I am writing in response to comments made by consultants regarding the proposed development of a care home in Middleton-on-Sea on a site which currently has planning permission for 13 individual private dwellings, and is the subject of Planning Application M/80/19/PL.

In his email of 12 December 2019 Mr Adrian Kearley makes reference to supplementary drawings of the existing plan for 13 houses and that of the proposed care home to support his statement “when including both built form and hardstanding the site coverage will increase moderately from 38.5% to 45.3%”. To support this statement, he made reference to two diagrams labelled 04.02 & 04.03.

SITE LAYOUT

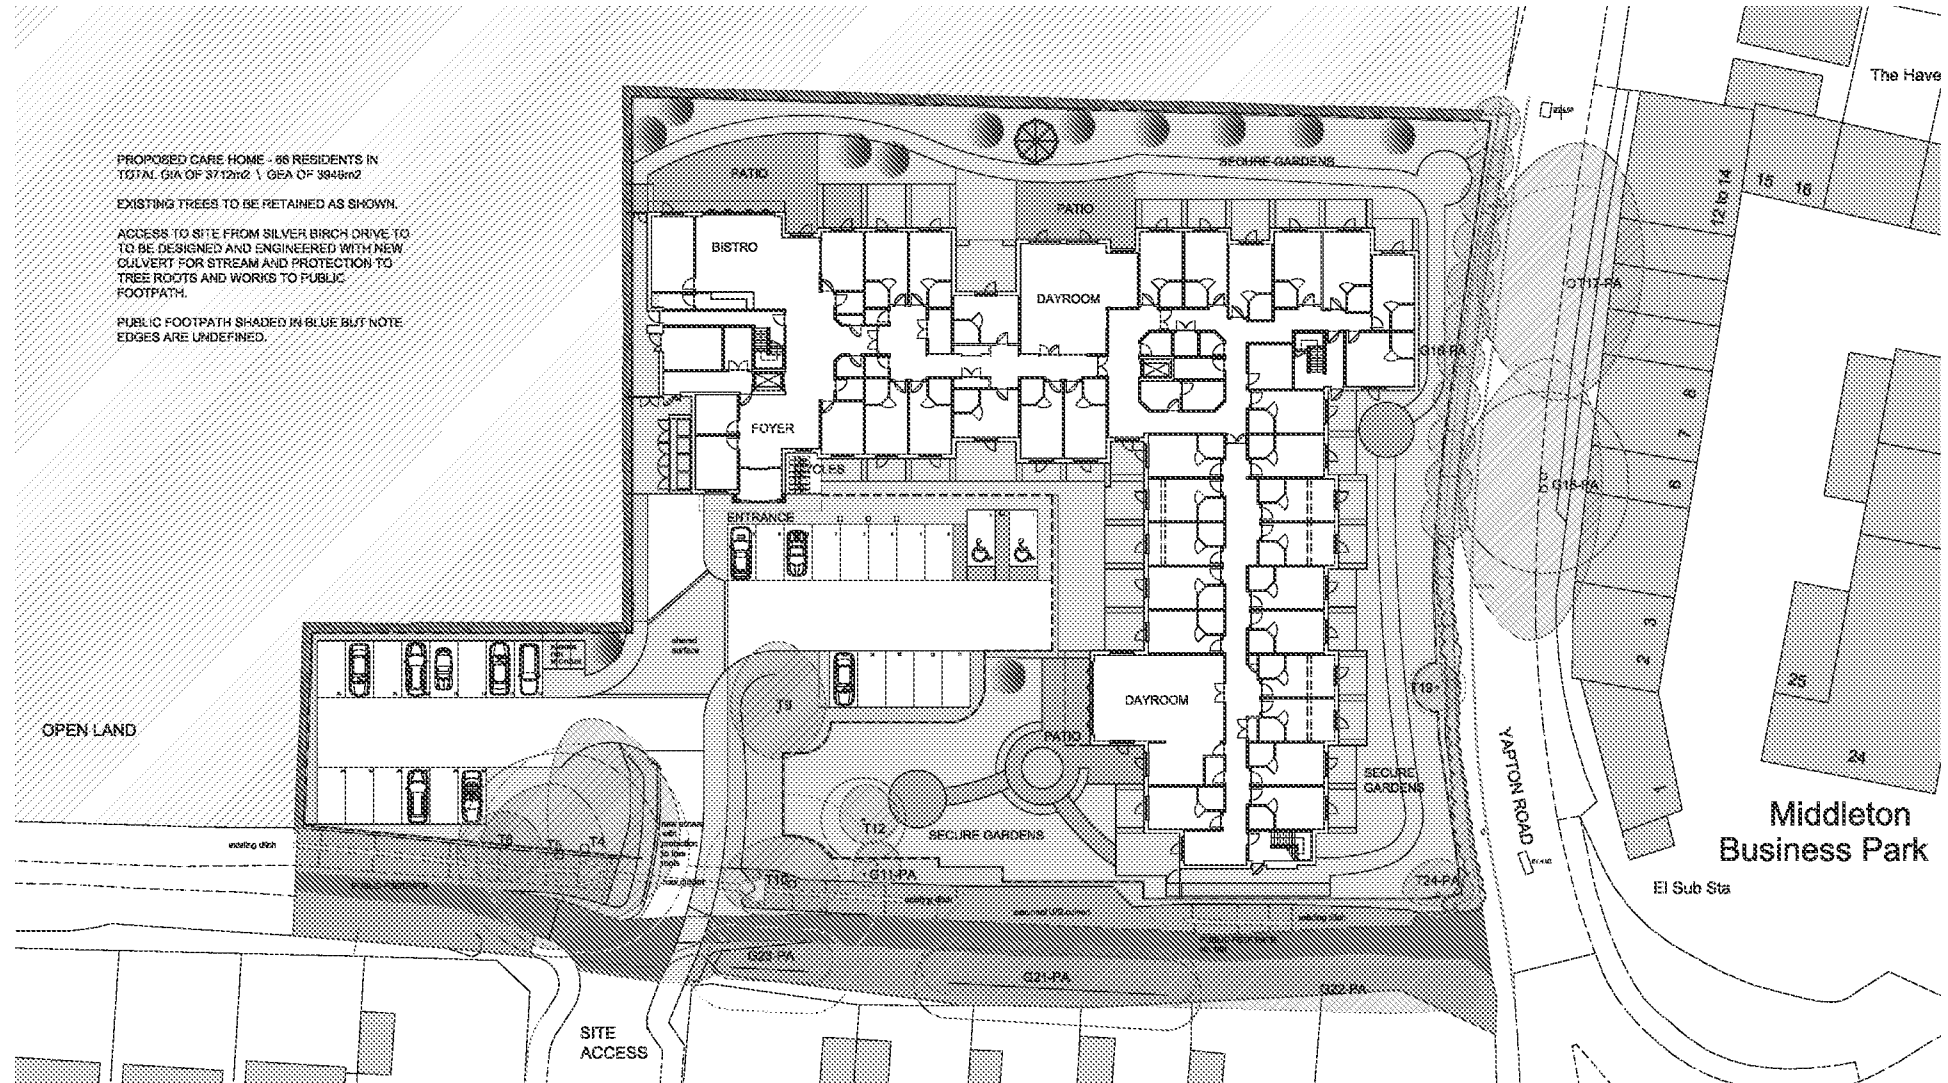
Firstly, it was interesting to note that on the care home drawing the patio areas outside the ground-floor rooms and the pathways to the east and north are not marked as hardstanding on the diagrams in spite of the fact that they will invariably be covered or paved with stone. These areas are marked in yellow on the attached diagram (see Attachment 1). This issue has now been addressed by Tim Spencer in his email dated 2 Jan 2020 in which he states that the amount of paved and surface area within the gardens for the care home is 730m², which includes spaces adjacent to the units as well as the walkways within the landscaping areas. However, these areas were not included in the figures displayed on Mr. Kearley’s diagrams, and it is now clear that for the care home the total building and hardstand area should have been 1737m² + 1095m² + 730m² = 3562m². This represents 57% of the total site area of 6246m² – much larger than the 45.3% stated on the diagram.

PREVIOUSLY CONSENTED RESIDENTIAL DEVELOPMENT

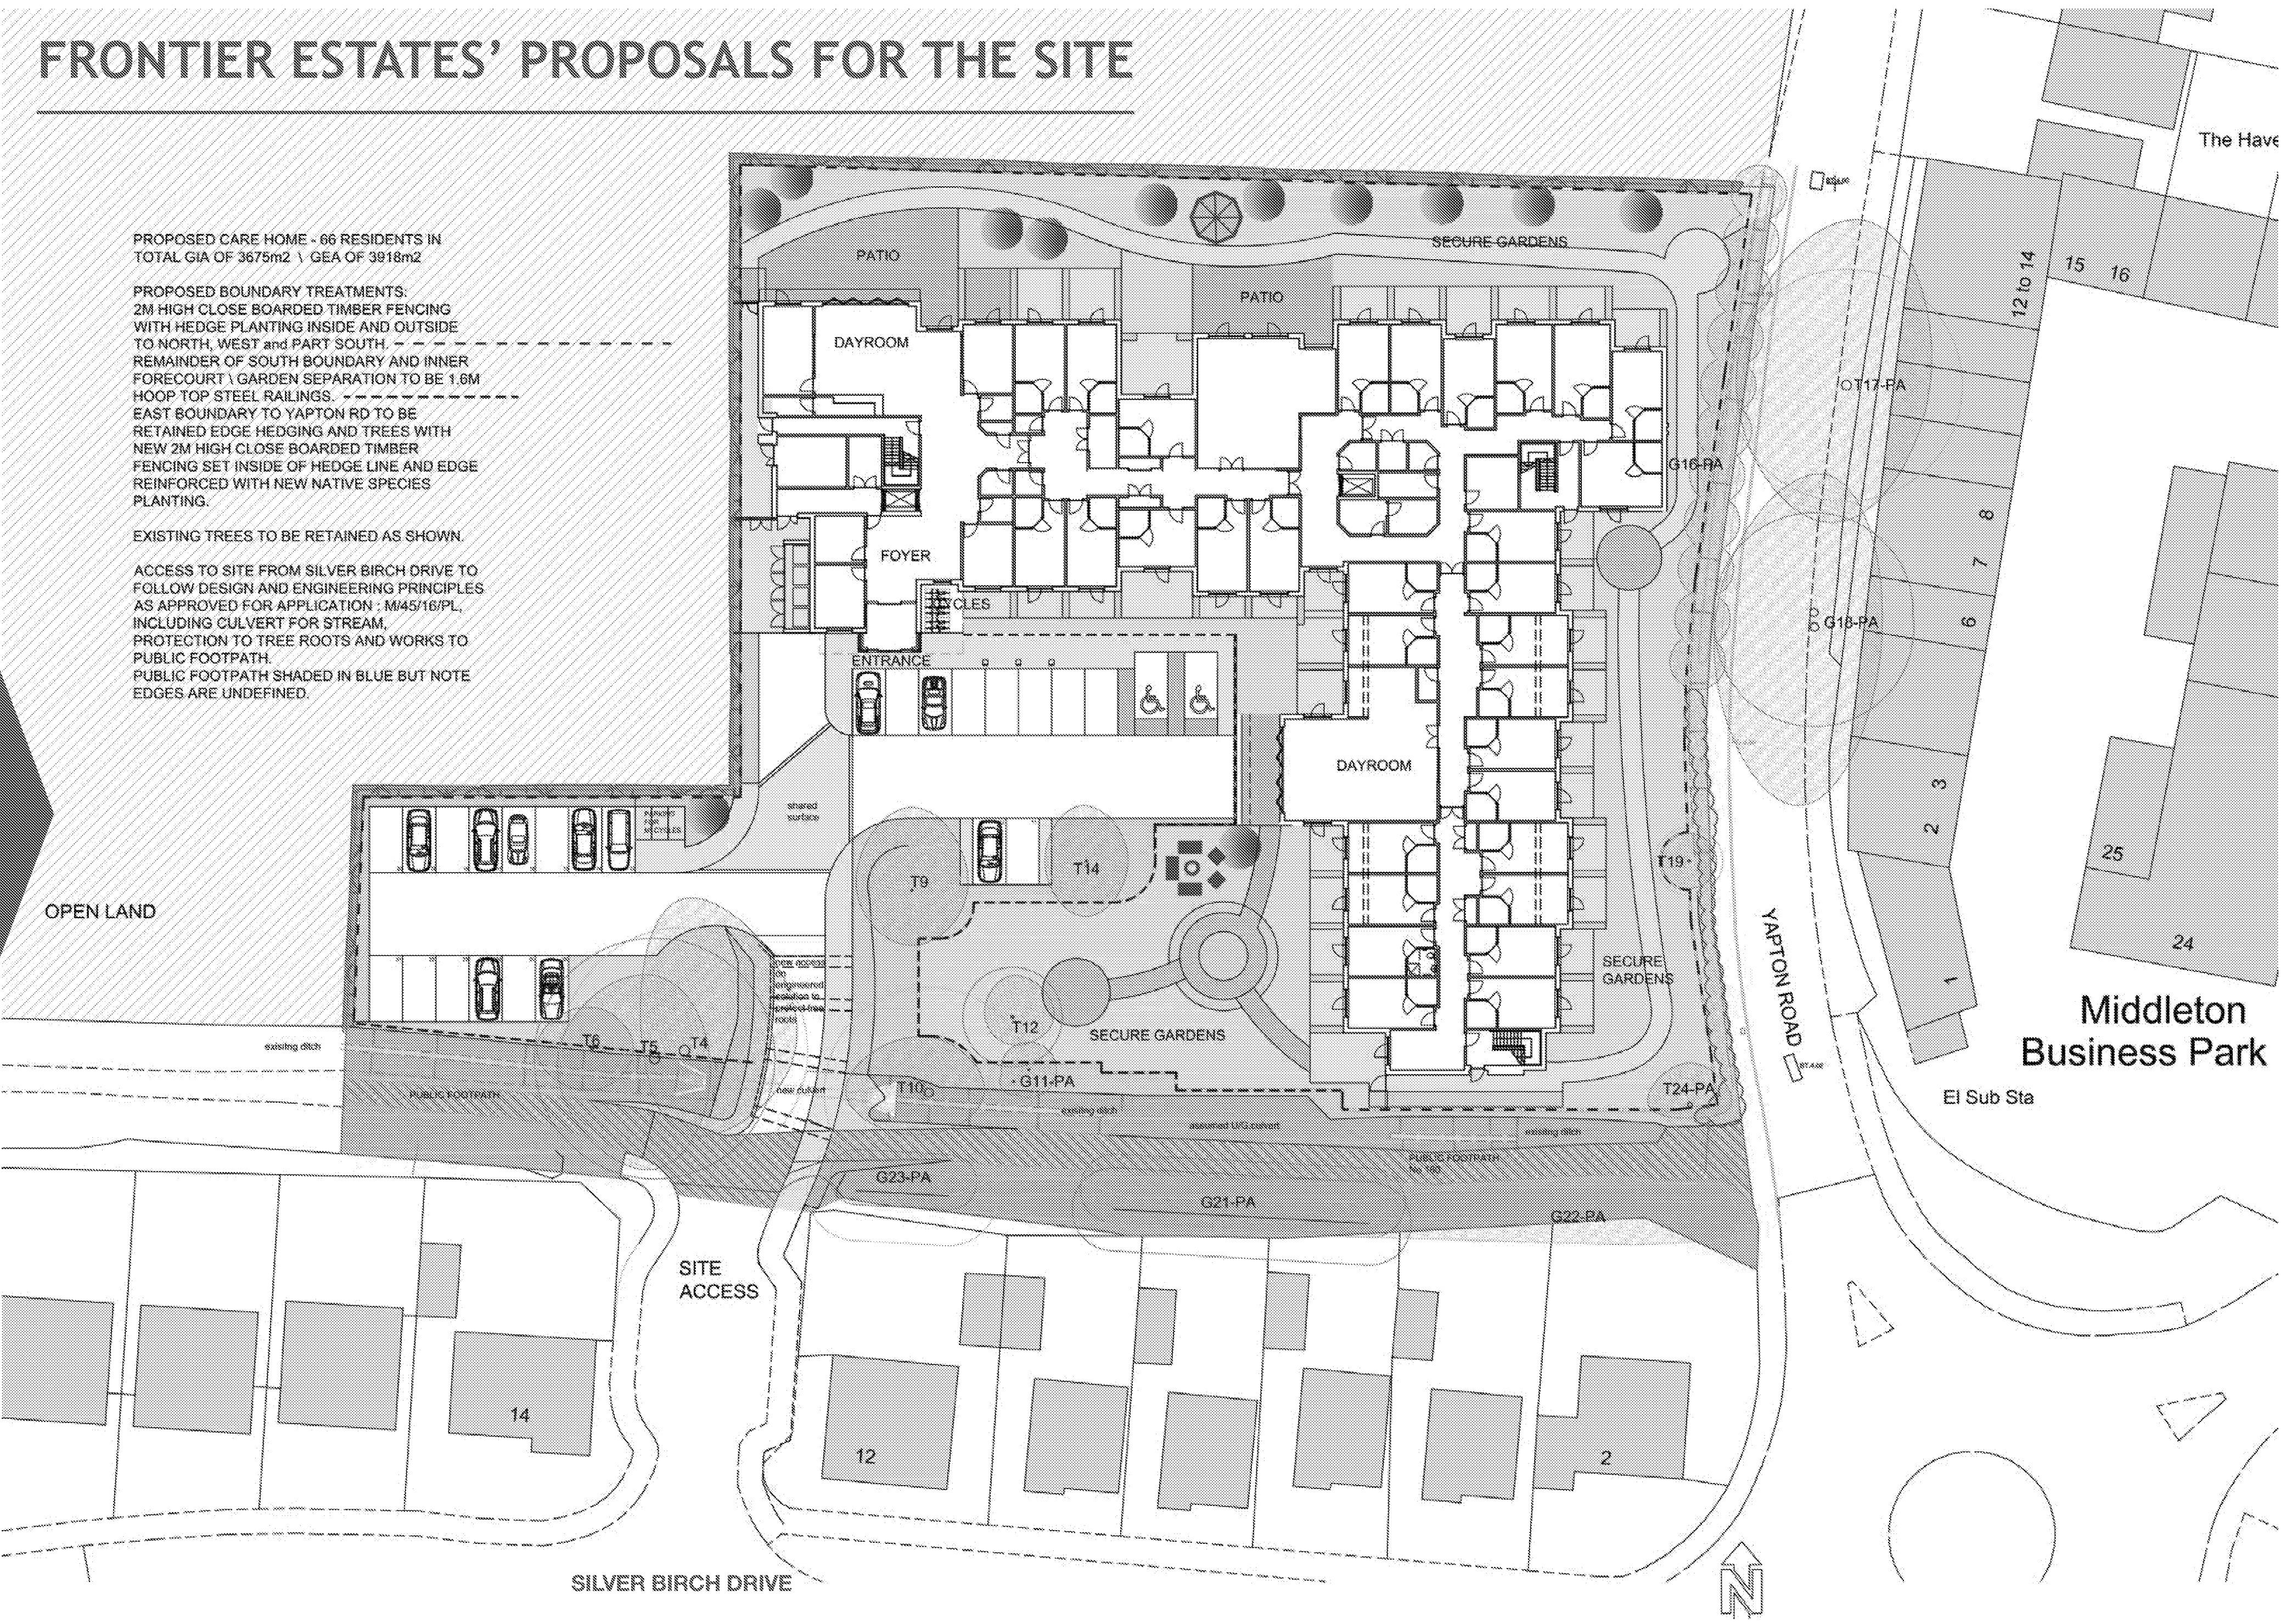
I contest that Mr. Spencer’s reference to hardstanding and patio areas for the extant housing scheme is spurious. It is entirely supposition and even if it were true I believe that the estimate of 20m² per house is excessive. Examination of diagram 04.3 (Attachment 2) shows that this would mean such patios would occupy about a third of each garden, and how many private residential dwellings have patios that do this, and are as large 4mx5m? Even if Mr. Spencer’s figures were entirely true the relative increase in hardstanding area between the plans would be 30%.
